**RE: Ketan Patel Residence
413 Monte Largo NE
Grading and Drainage Plan
Engineers Stamp Date 8/4/15 (K23D028)**

DRAINAGE AND TRANSPORTATION INFORMATION SHEET

Project Title: 721 413 MONTE LARGO Building Permit #: _____ City Drainage #: K23D028

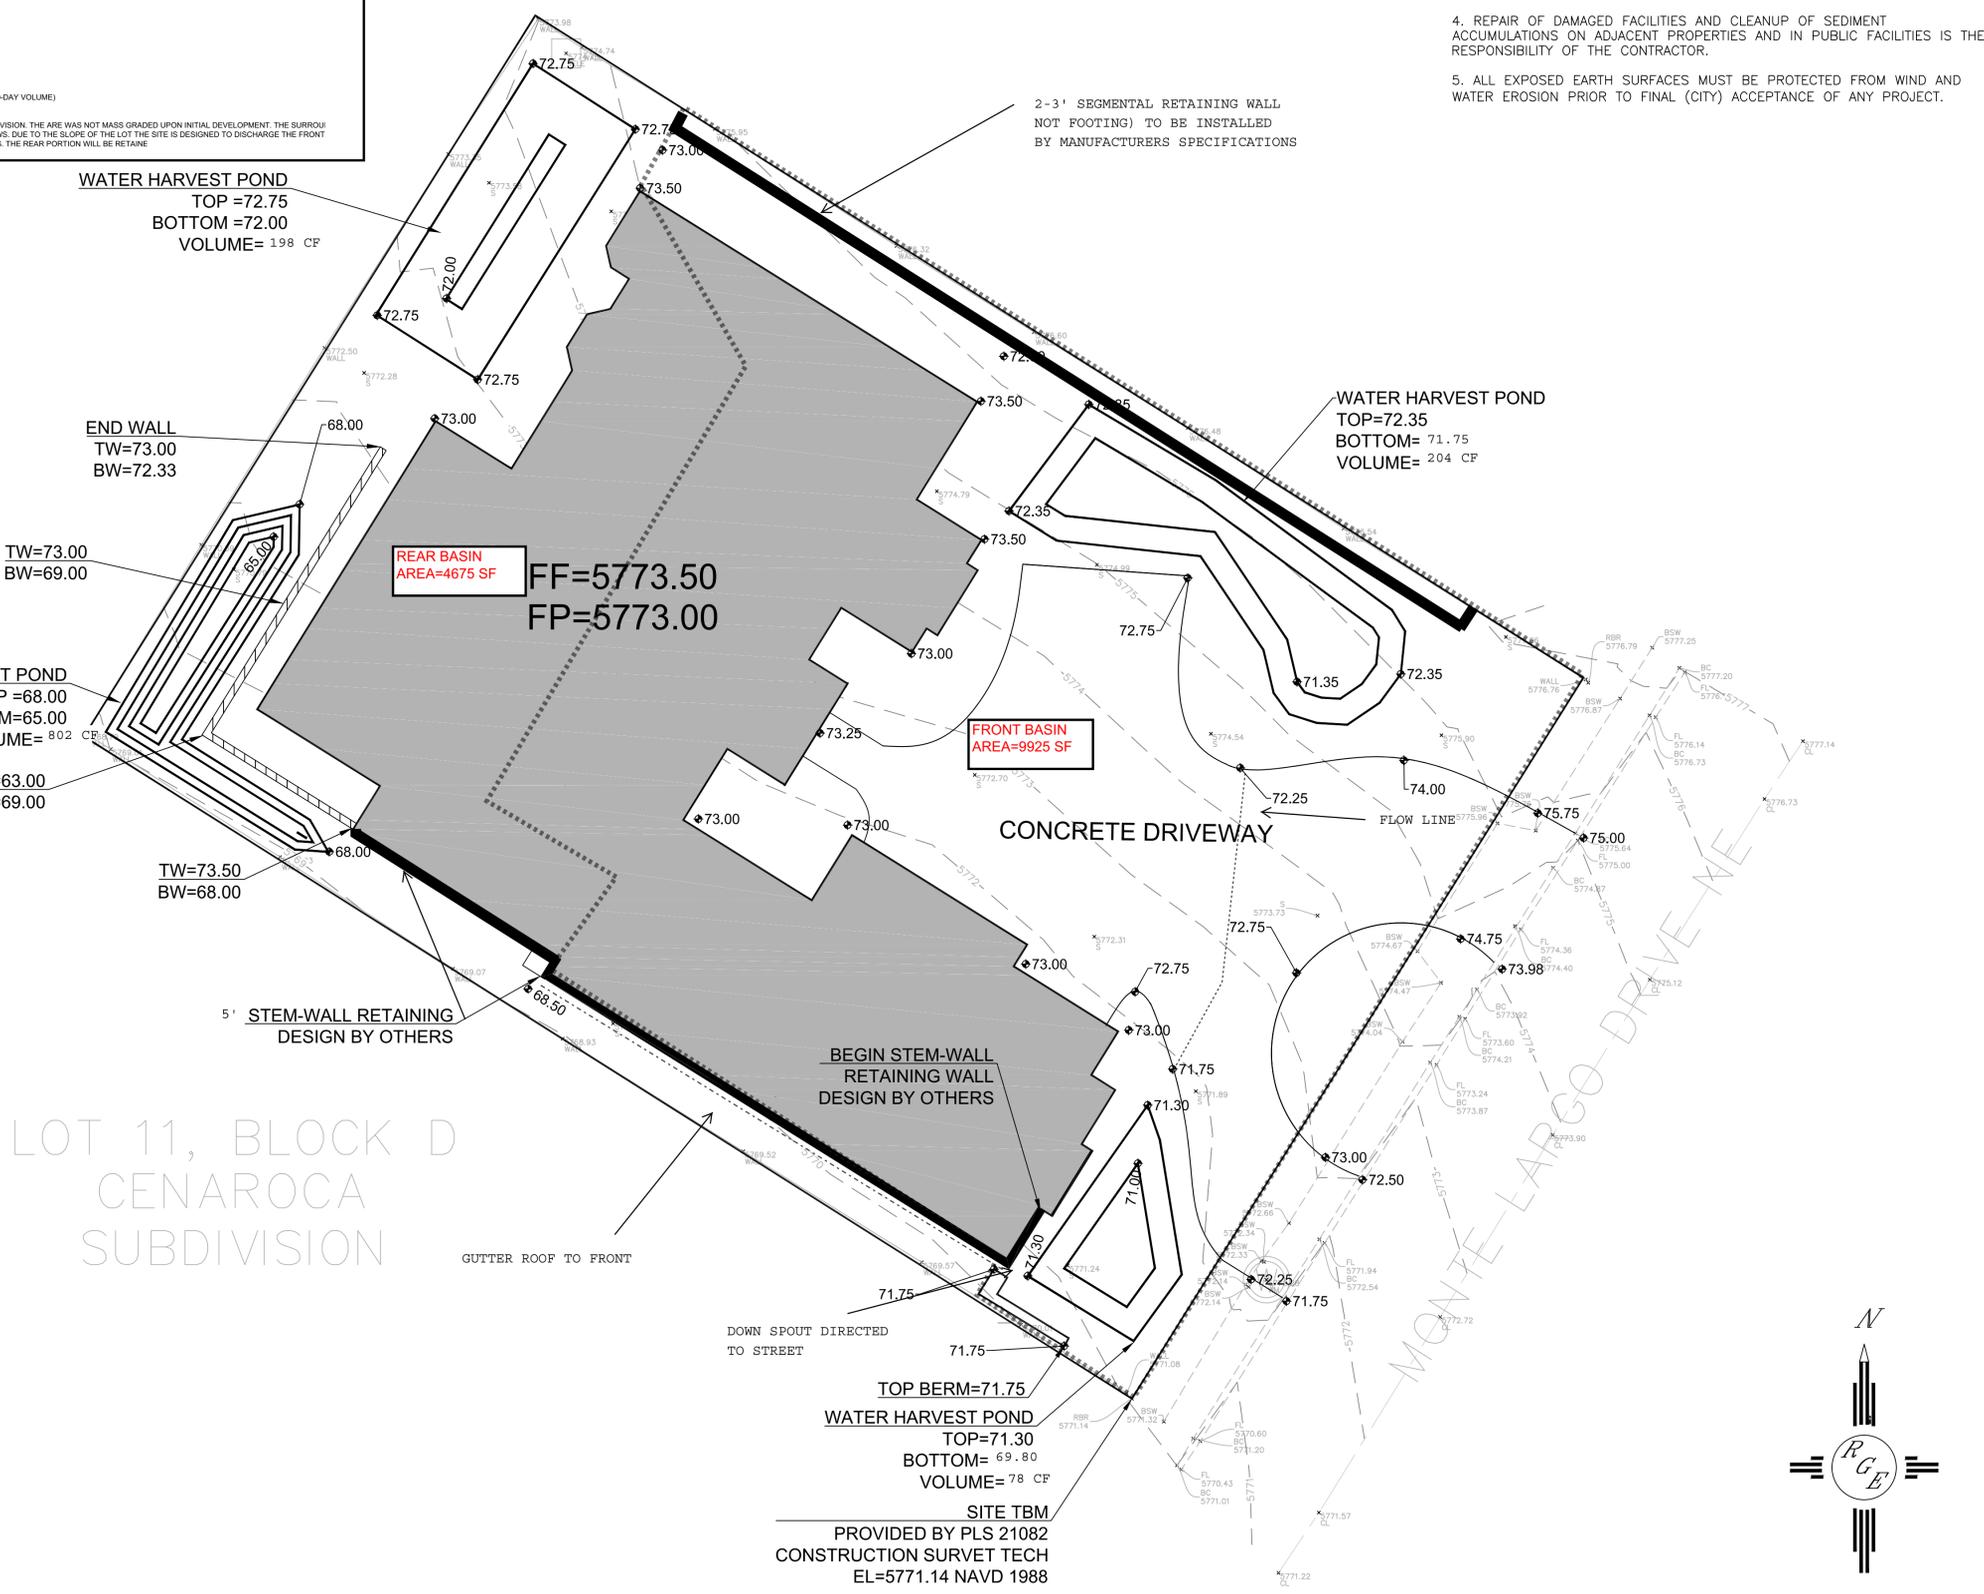
Verbal NO

Contours wrong
Need pipe calcs
Need FF Reg'
